Sea Link Volume 9: Examination Submissions Document 9.34.6 Applicant's Thematic Responses to Relevant Representations Planning Inspectorate Reference: EN20026

Response from Alison Andrews. relevant to i. beach erosion ii. maritime heritage at land fall.

7.6.3 – Beach Erosion Concerns Modelling must be open and conservative. Local residents experience beach changes year-to-year — the Applicant must provide long-term monitoring and a liability framework for any induced erosion.

**Figure 1. Landfall Concept Drawing (see page below)**

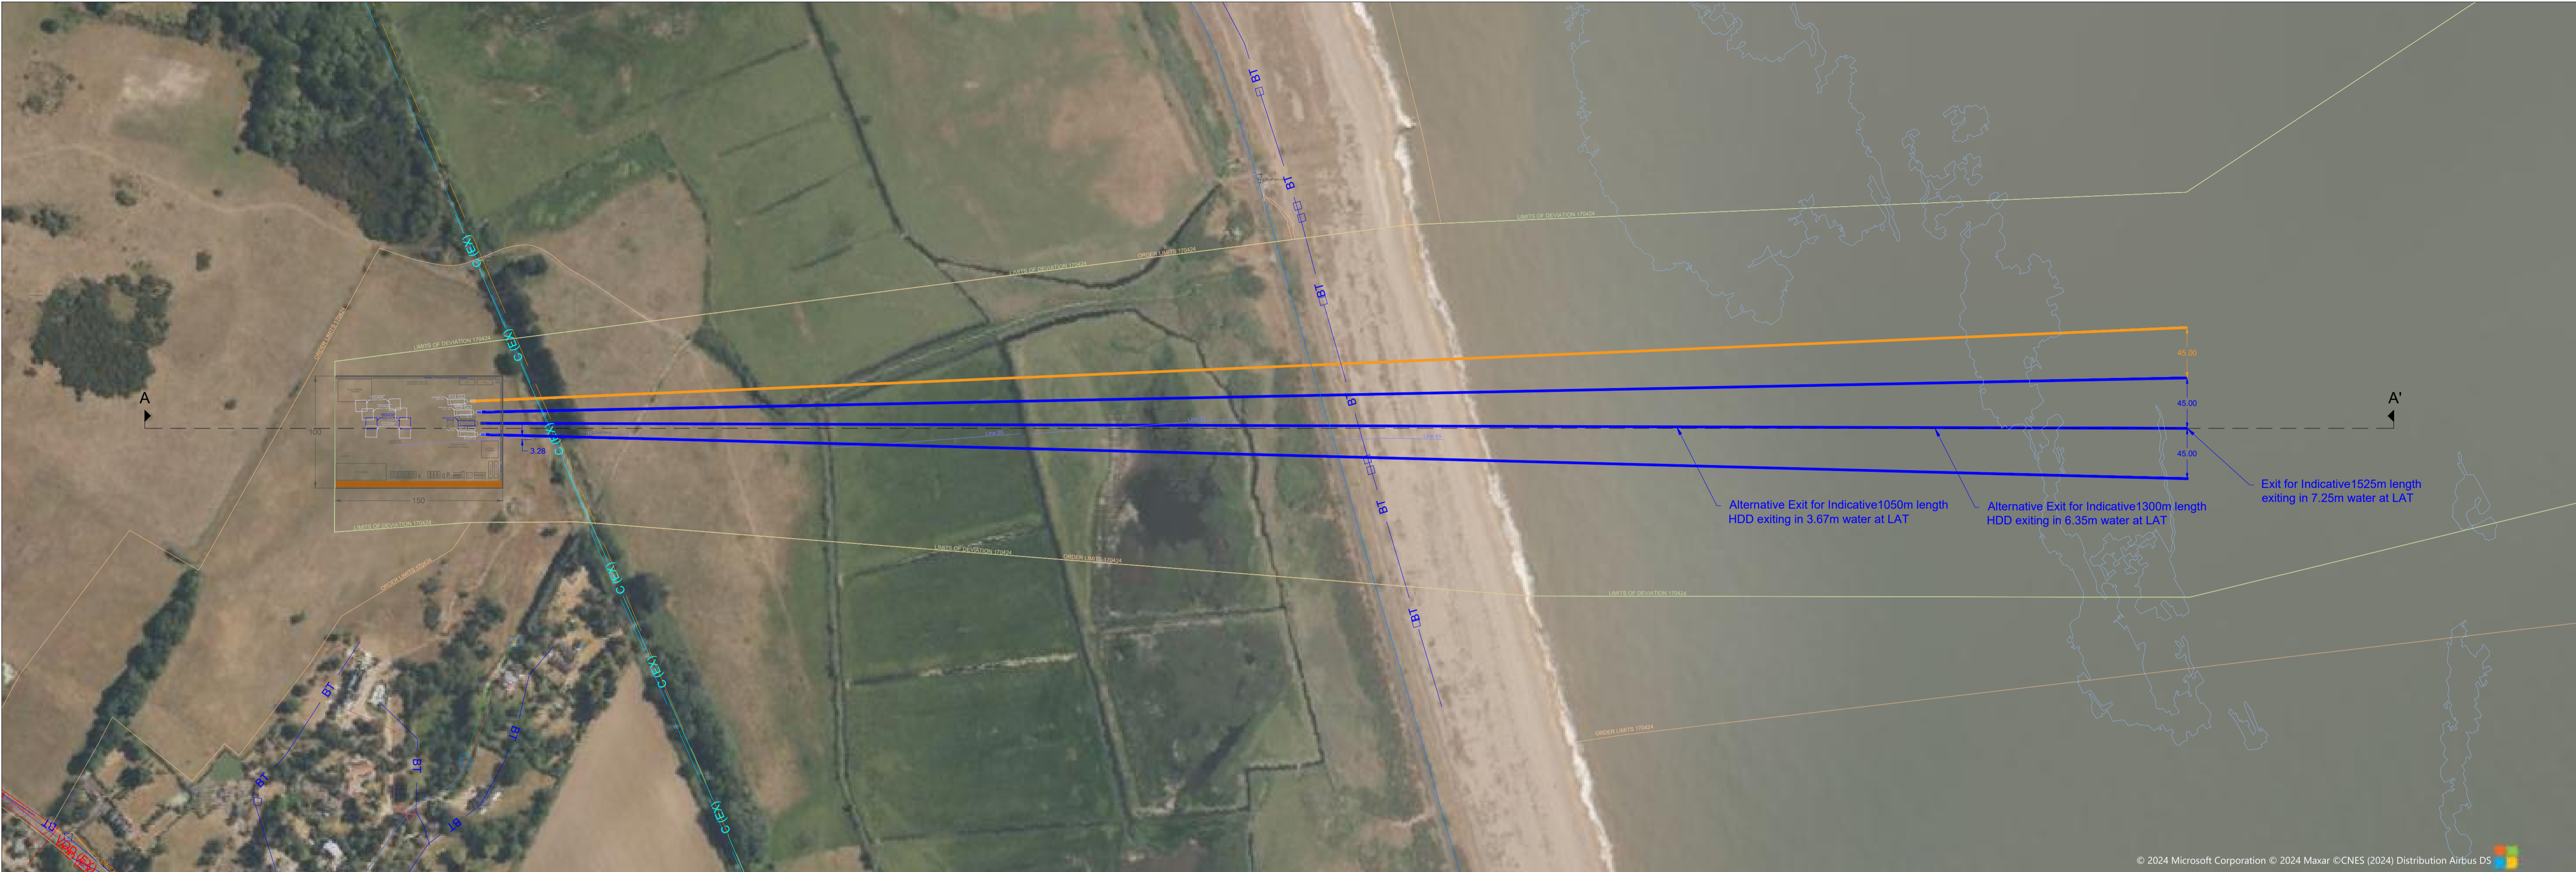
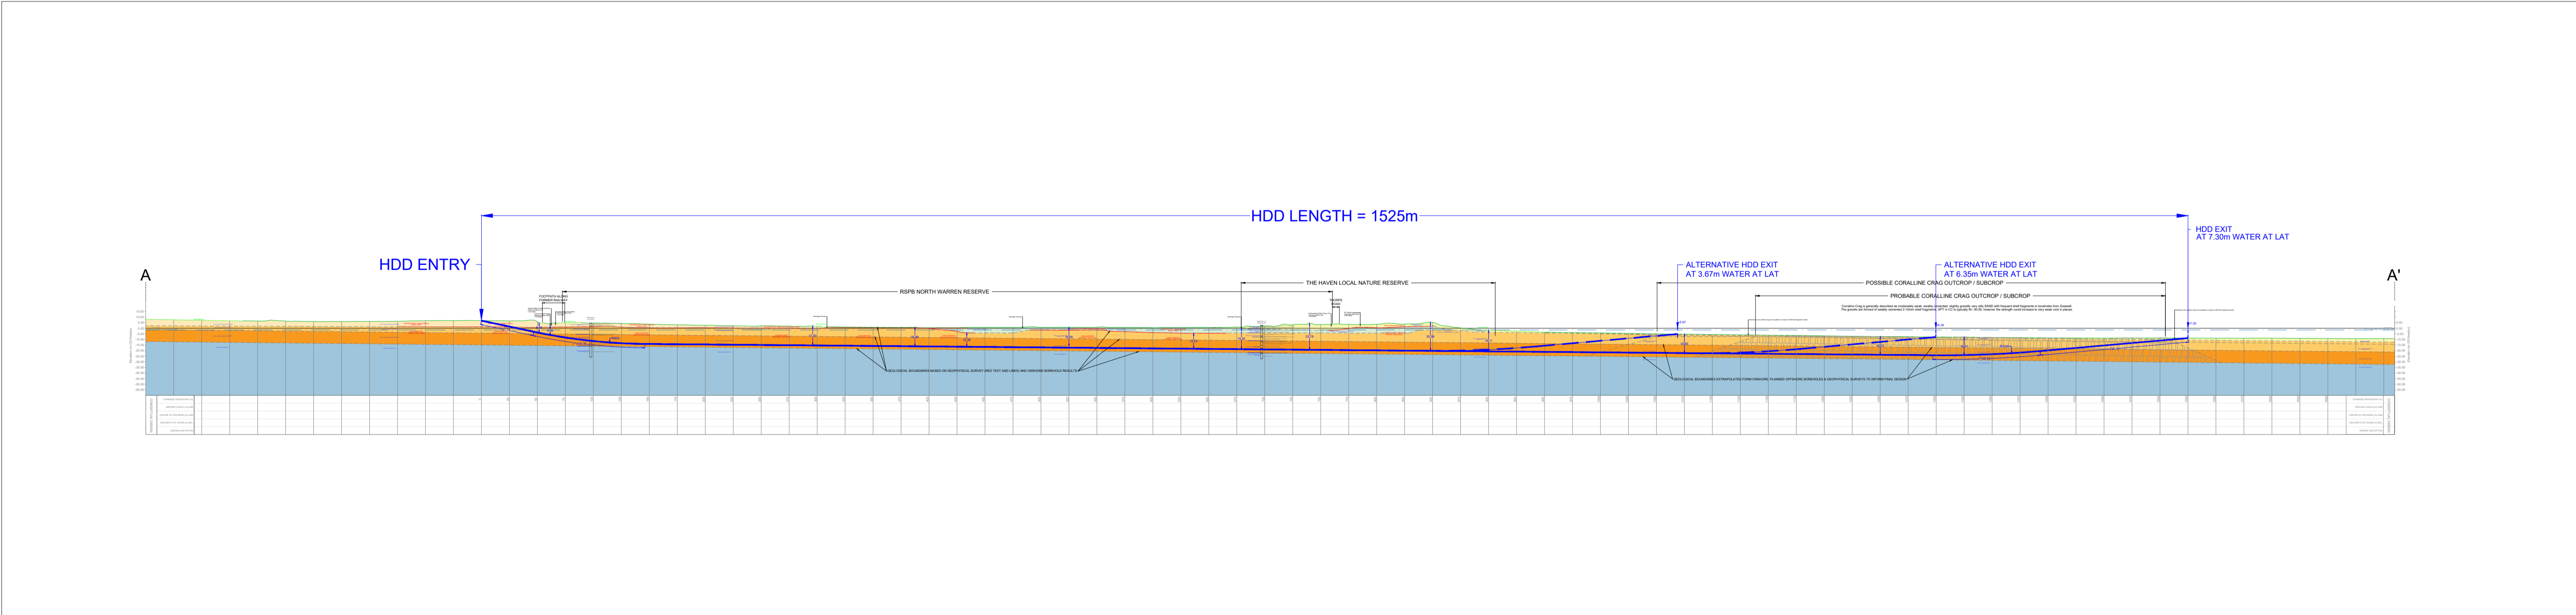
The shoreline can change overnight. Has this been taken into account? As an example of what can happen, Concerto fibre optic telecommunications cable became fully exposed overnight by high winds and tides in October 2018, immediately north of Thorpeness Cliffs, after being installed and buried well below the beach by internationally expert company only about 10 years earlier. For the project, Table 1.18 indicates an HDD Depth of lowering: 0 m to -2 m below seabed level. Table 1.18 on page 80 comments The cable system installation is designed such that a regular maintenance regime is not required to maintain the integrity of the link.

Can concerns about any landfall on this Suffolk coast be so easily dismissed as negligible and will the cables be secure. Later, REP1-051 reports in 1.9.27 At the Suffolk landfall site, The Anglian Regional Coastal Monitoring Programme (2022) has calculated there is a long-term erosional trend since 1991. In more recent years (2016 - 2021), there has been notable acceleration in the erosion rate around the landfall site between Thorpeness and Aldeburgh (See Section 1.7). The sensitivity of the coastal morphology at the Suffolk landfall is therefore assessed to be high. But REP1-051 then goes on to say the area affected will be small. Has enough consideration been given to this essentially very mobile shingle, gravel and sandy shoreline and sea bed?.

Figure A5. Profile changes 2013-2021 – Profile S040

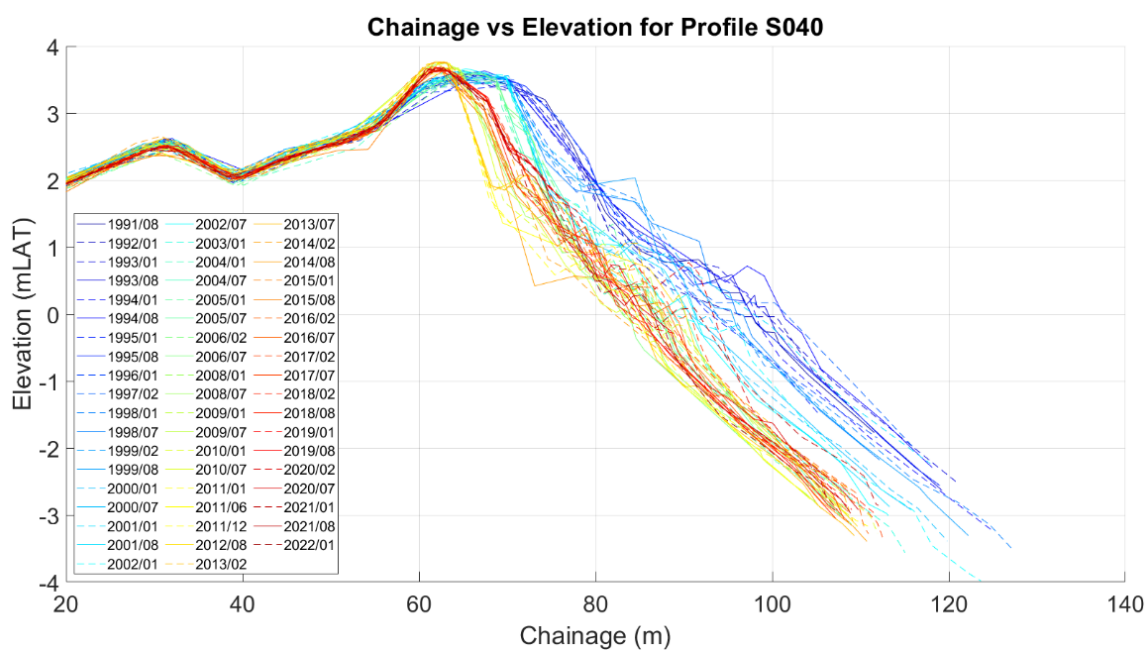
1.7.42 Transect S040 (which directly aligns with the Suffolk landfall site) is reported to show a net loss of intertidal beach since 1991,
